**EL PASO COUNTY PLANNING AND
 COMMUNITY DEVELOPMENT
 DEPARTMENT**

STORMWATER MANAGEMENT PLAN CHECKLIST

GRADING & EROSION CONTROL PLAN
CLAREMONT BUSINESS PARK FIL. NO. 3
JOB NO. 44-037
DATE PREPARED: APRIL 28, 2020
DATE REVISED:

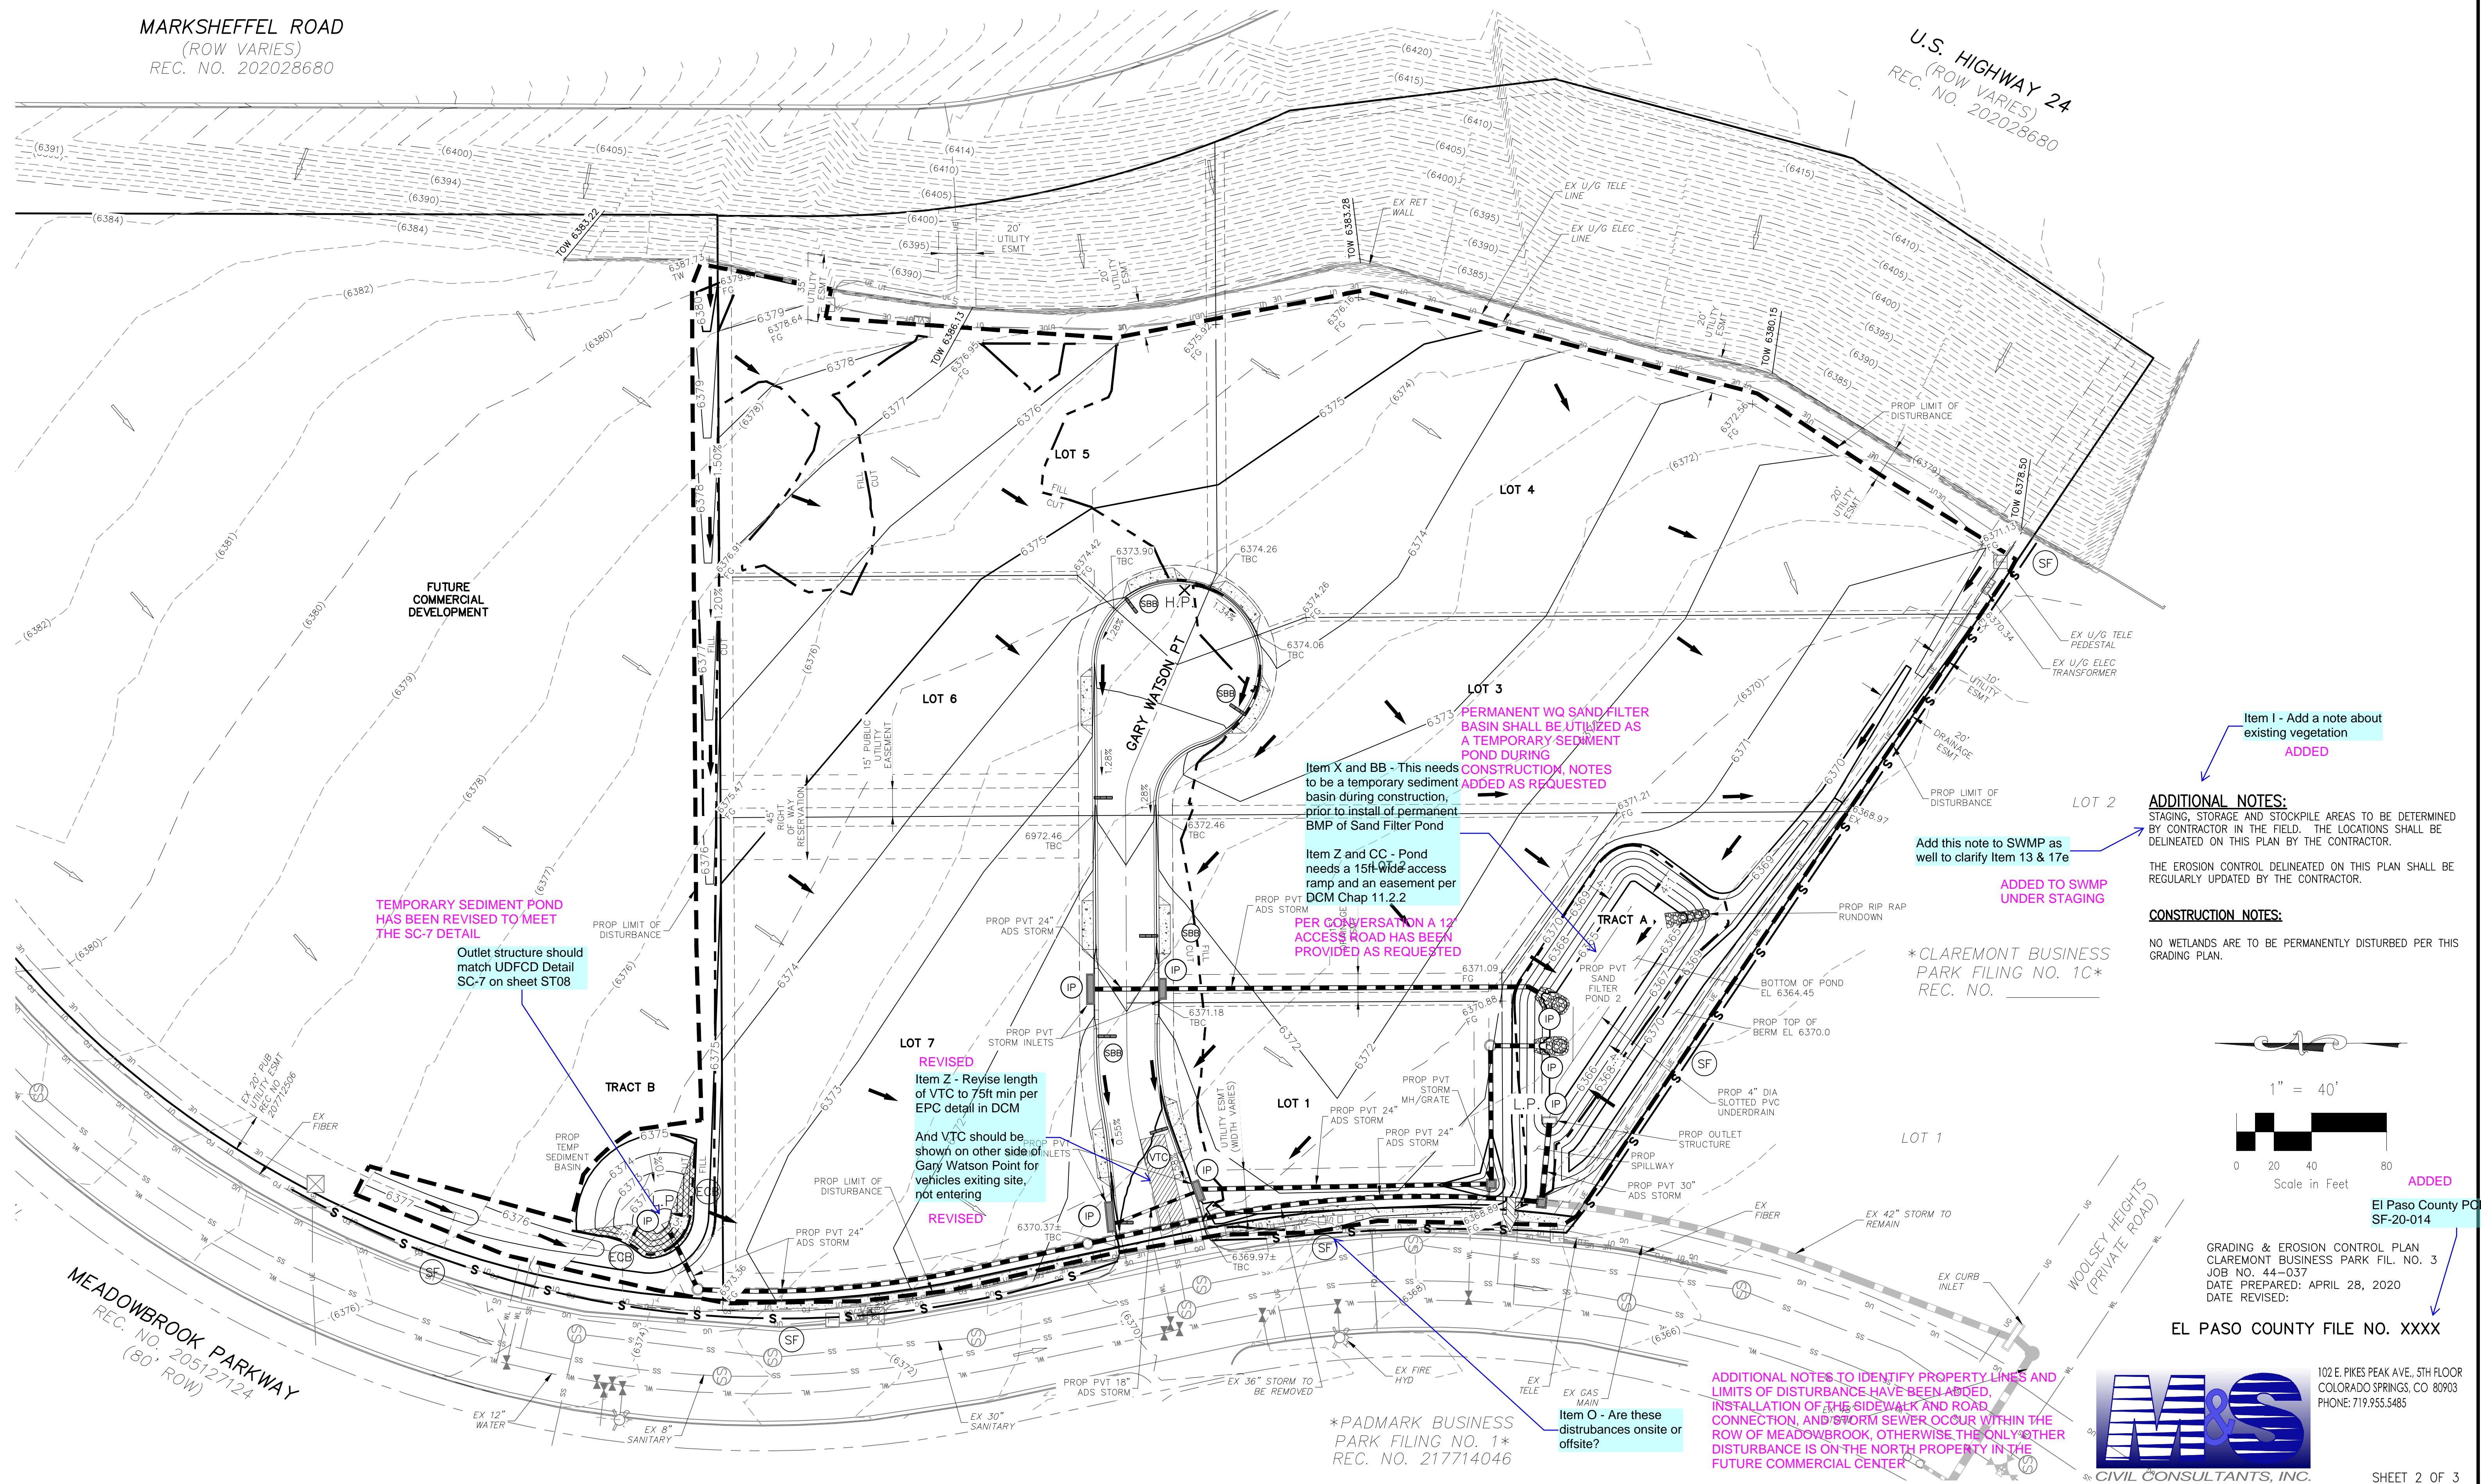
Revised: July 2019		Applicant	PCD
17	SWMP Map to include: property boundary and limits of construction has been delineated on the Early Grading and GEC Plans		
17a	construction site boundaries See comments on GEC Plan - Sheet 1 of 3	X	X
17b	flow arrows to depict stormwater flow directions	X	✓
17c	all areas of disturbance	X	✓
17d	areas of cut and fill	X	✓
17e	areas used for storage of building materials, soils (stockpiles) or wastes	X	✓
17f	location of any dedicated asphalt / concrete batch plants details updated and or added	N/A	✓
17g	location of all structural control measures See comments on GEC Plan - Sheet 1 of 3	X	X
17h	location of all non-structural control measures See comments on GEC Plan - Sheet 1 of 3	X	X
17i	springs, streams, wetlands and other surface waters, including areas that require maintenance or pre-existing vegetation within 50 feet of a receiving water details updated and or added	N/A	✓
